Comment from Greenspace

APPLICATION EP/77/17/DOC

Site Address: Bradbury Hotel Station Road East Preston
BN16 3FF

Description of Works: Application for approval of details reserved by
condition imposed under planning permission
EP/63/16/PL relating to Condition No. 4

CLIENT	DENTON HOMES	REVISIONS
SITE	BRADBURY HOTEL BN16 3FF	
DRAWING	LANDSCAPE PLAN	
DATE	20-3-17	
DRWG NR	LC-2592-01	
SCALE	1:100 @ A1	
ISSUE	PLANNING

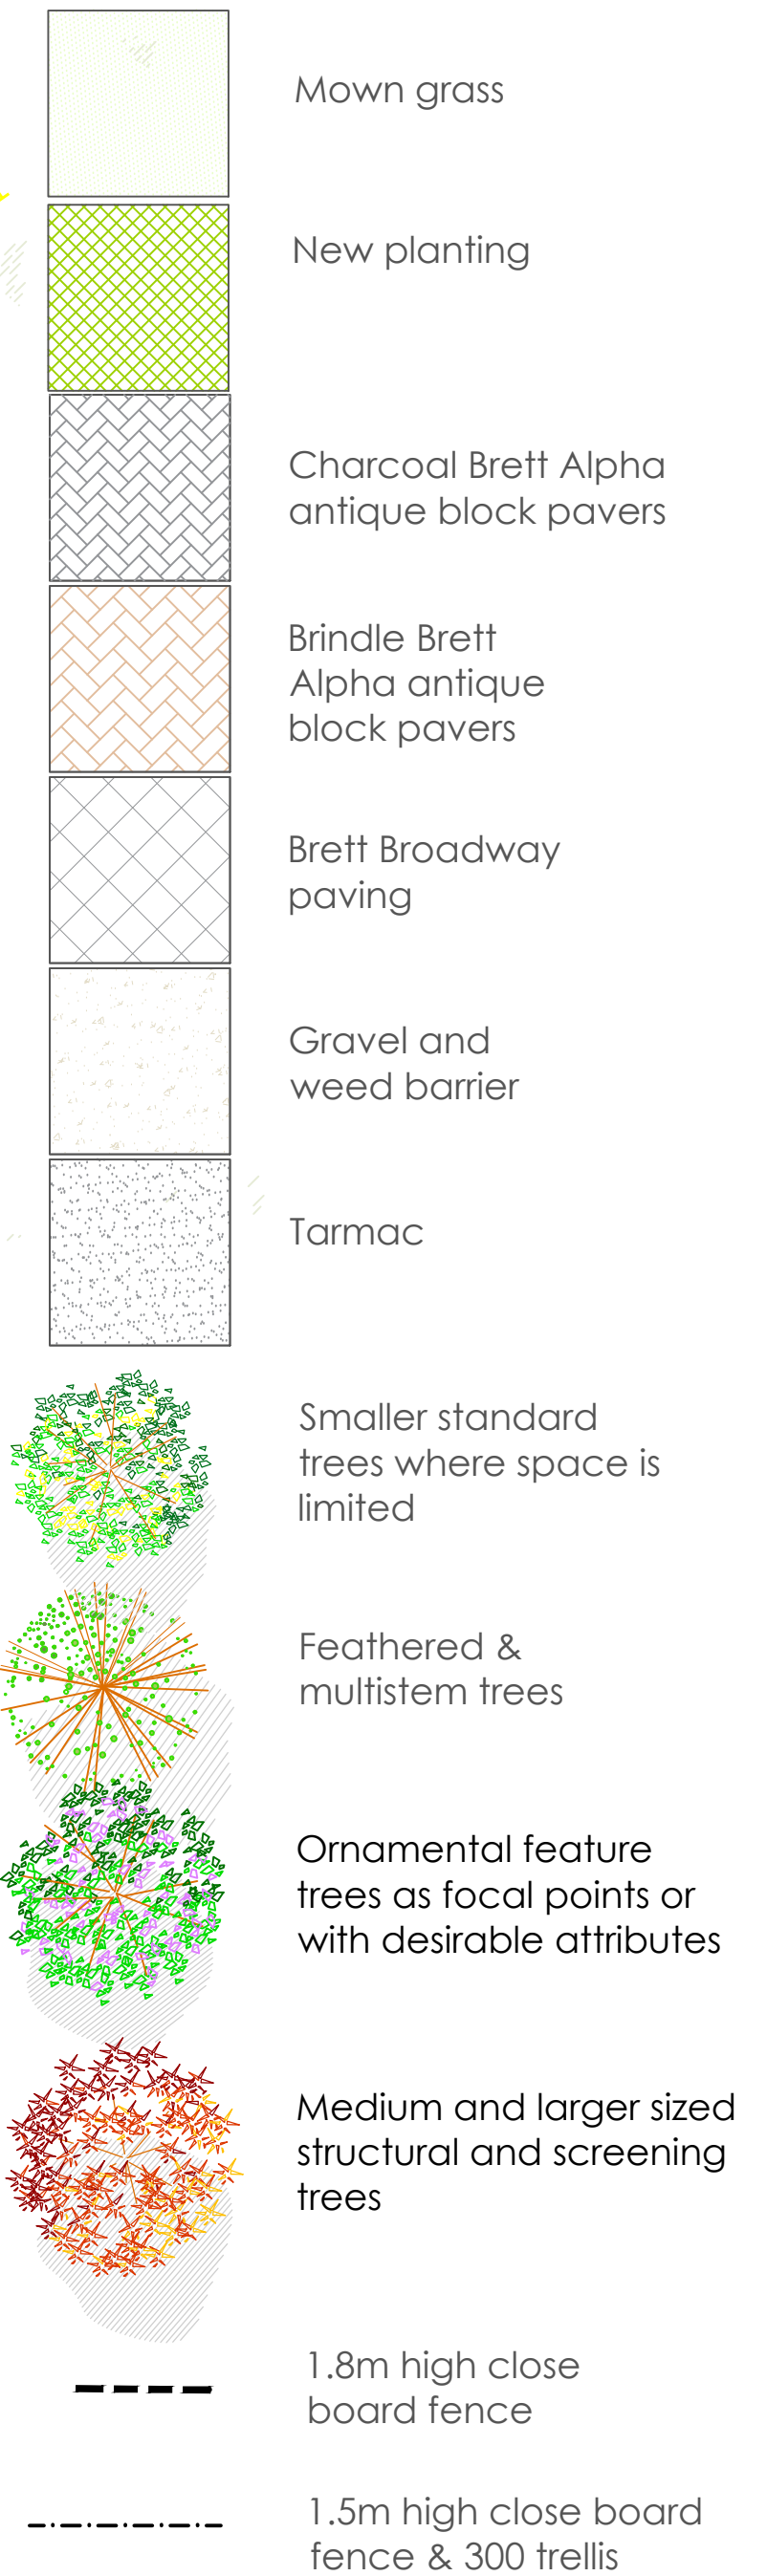
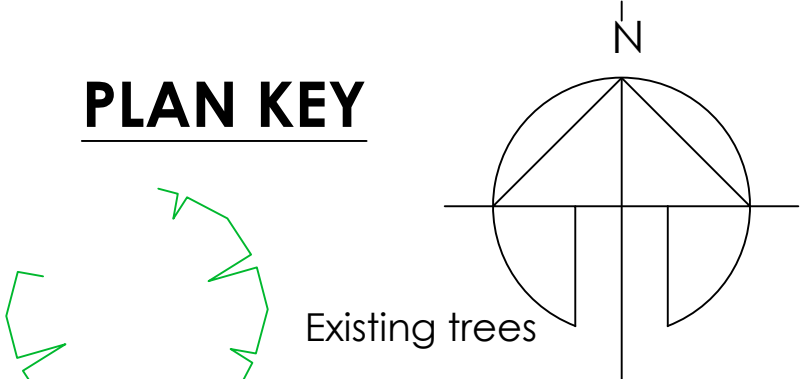
Further to the submission of the Landscape Plan LC-2592-01. We can confirm that this does now adequately contain the information that was requested under Condition 8 Landscaping imposed under EP/63/16/PL and **therefore advise that we would now recommend the discharge of Condition 8 on application EP/77/17/DOC.**
